From: Anita Gardner <Anita.Gardner@arun.gov.uk>
Sent: 21 July 2020 08:33
To: Planning.Responses <Planning.Responses@arun.gov.uk>
Subject: FW: EP/62/20/DOC - Gladwyn, The Street, East Preston

From: Ian Hayward [REDACTED]
Sent: 20 July 2020 08:48
To: Anita Gardner <Anita.Gardner@arun.gov.uk>
Cc: Nicola Fry [REDACTED]
Subject: RE: EP/62/20/DOC - Gladwyn, The Street, East Preston

Nicki did a response on 12/06/2020 signing off details for conditions 4 (Visibility Splays) and 6 (Cycle Parking). A slight modification was requested for Condition 5 (Parking & Turning). This was made and Nicki confirmed plans and details for condition 5 were acceptable as per response dated 23/06/2020.

From what I can see Nicki's latest comments were based on the most recent plans and details namely - Landscaping and external works (2386/01/12) & Block plan, bin store elevations (2386/01/03/D).

Scales: 1:50 1:200
No: 2386/01/12

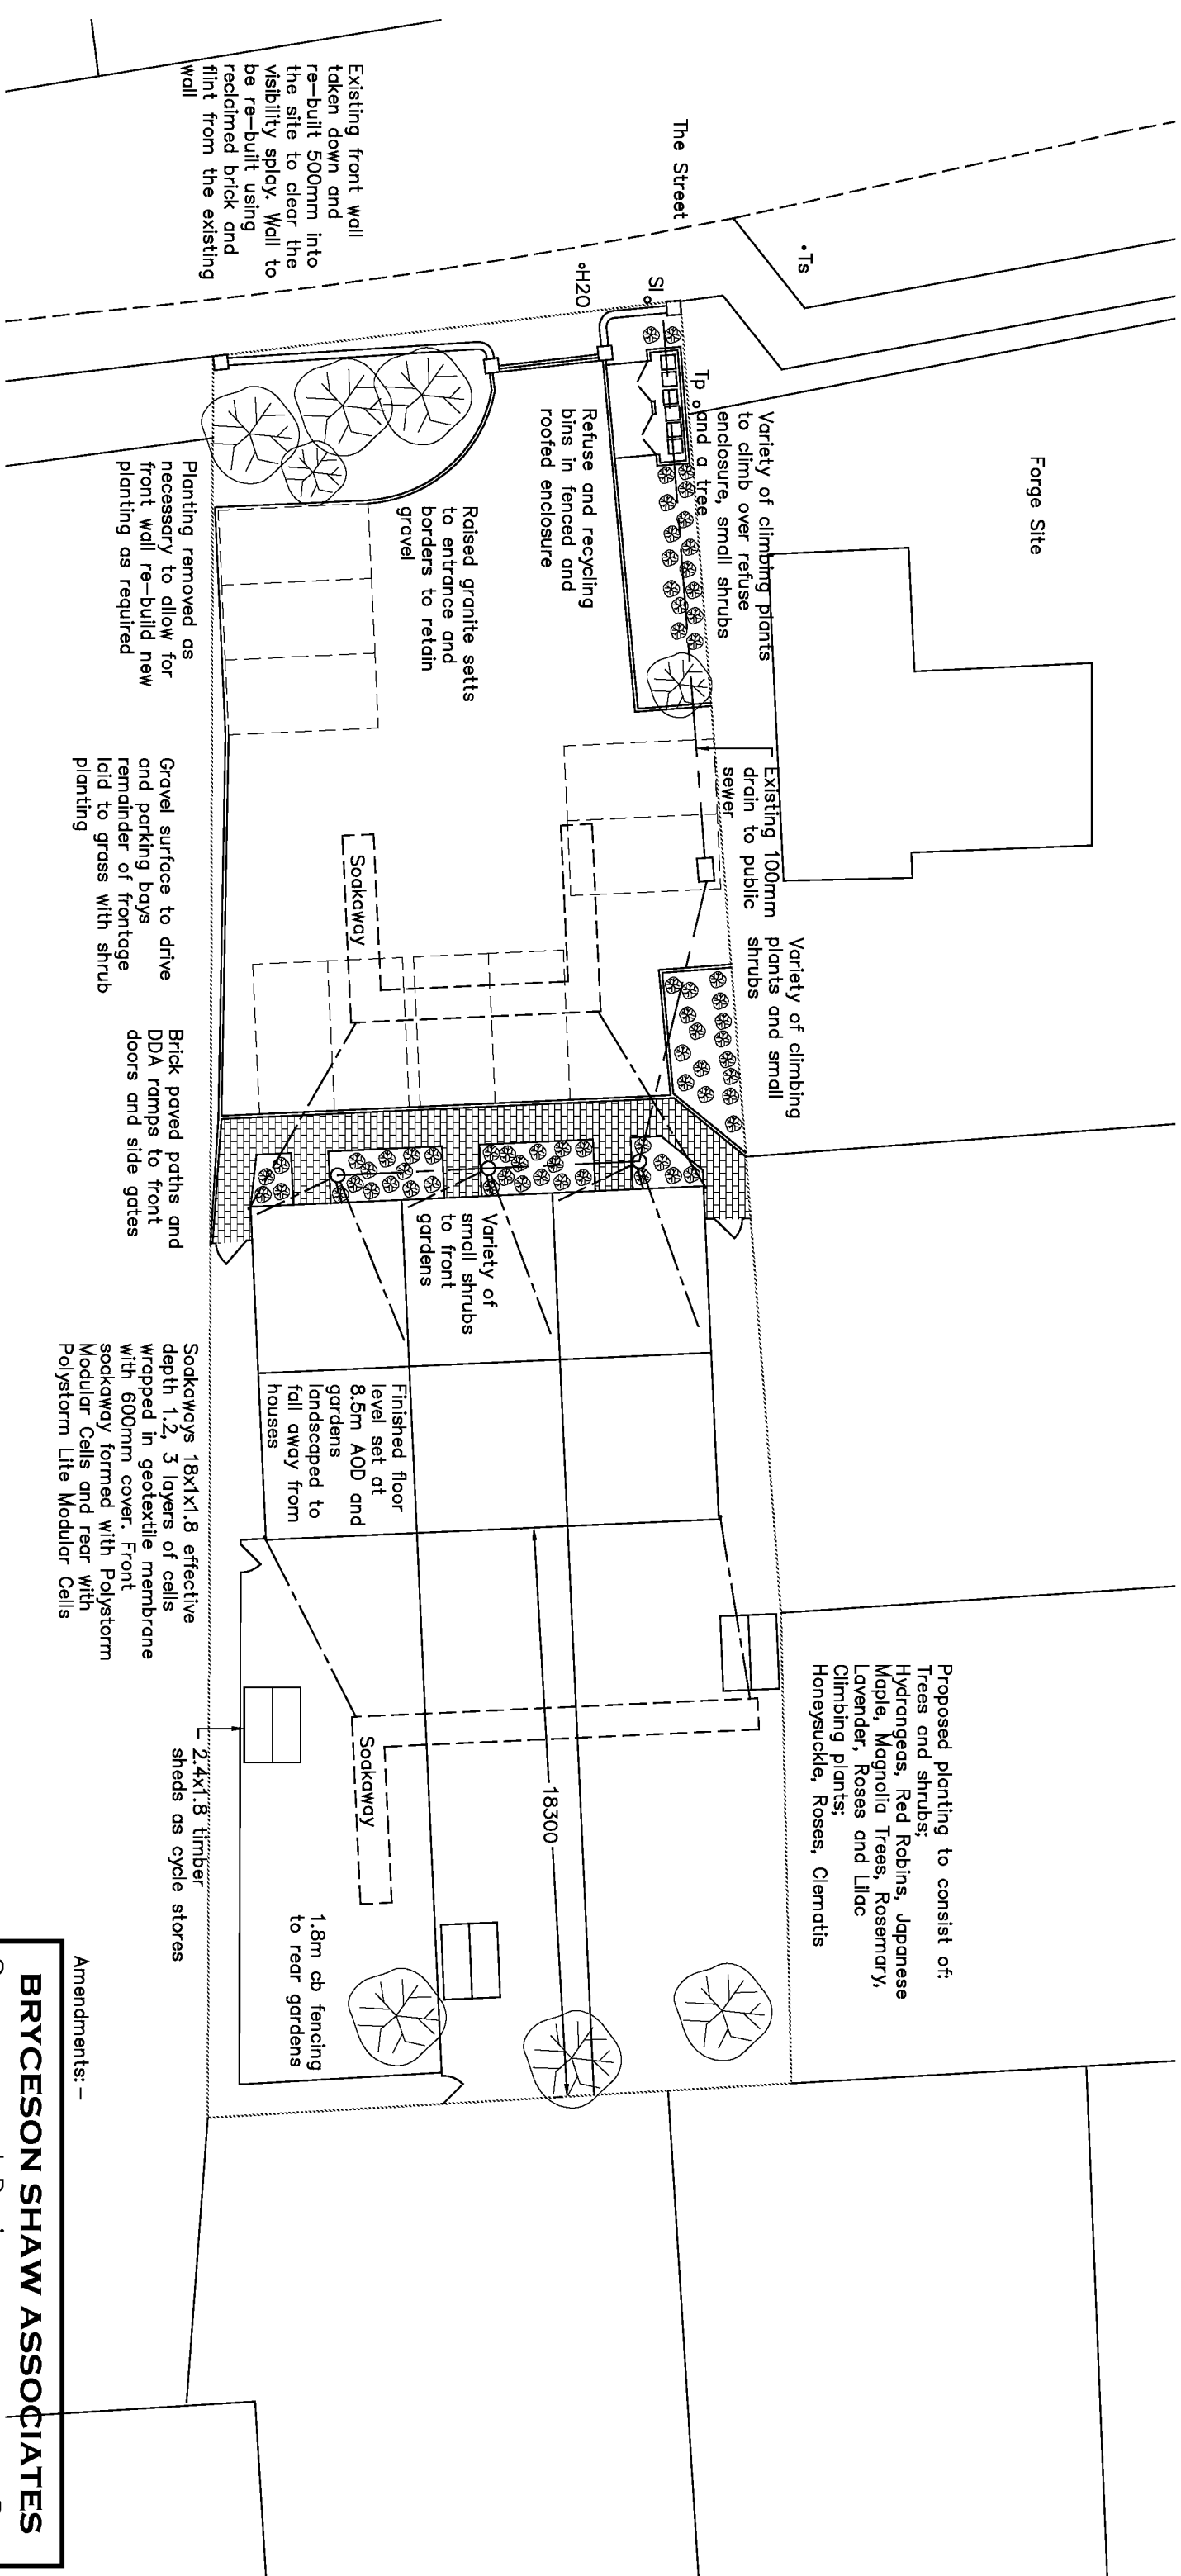
I have been allocated the above application and am carrying out the relevant consultations with other departments. However in the meantime I note that the information submitted with regard to discharge of conditions 8 -hard & soft landscaping and 10 - existing wall to south, lack sufficient detail at this stage. I will require confirmation of pot and plant sizes and plant numbers and details of replacement planting for the existing front border where the wall is being demolished and details of tree hedge retention and protection. For the walling the condition requires details of method of demolition and rebuilding. I would suggest that photographs of the existing wall are provided as a reference point and that an elevation of the proposed replacement wall is provided to detail how existing bricks and flints will be reused together with the type of mortar and amount of protrusion of flintwork from cement.

I attached revised copies of drawings .../03D and .../12 with the altered parking space positions and the front garden wall re-building details together with clear photos of the wall. The wall is too overgrown to be clearly visible at the moment.
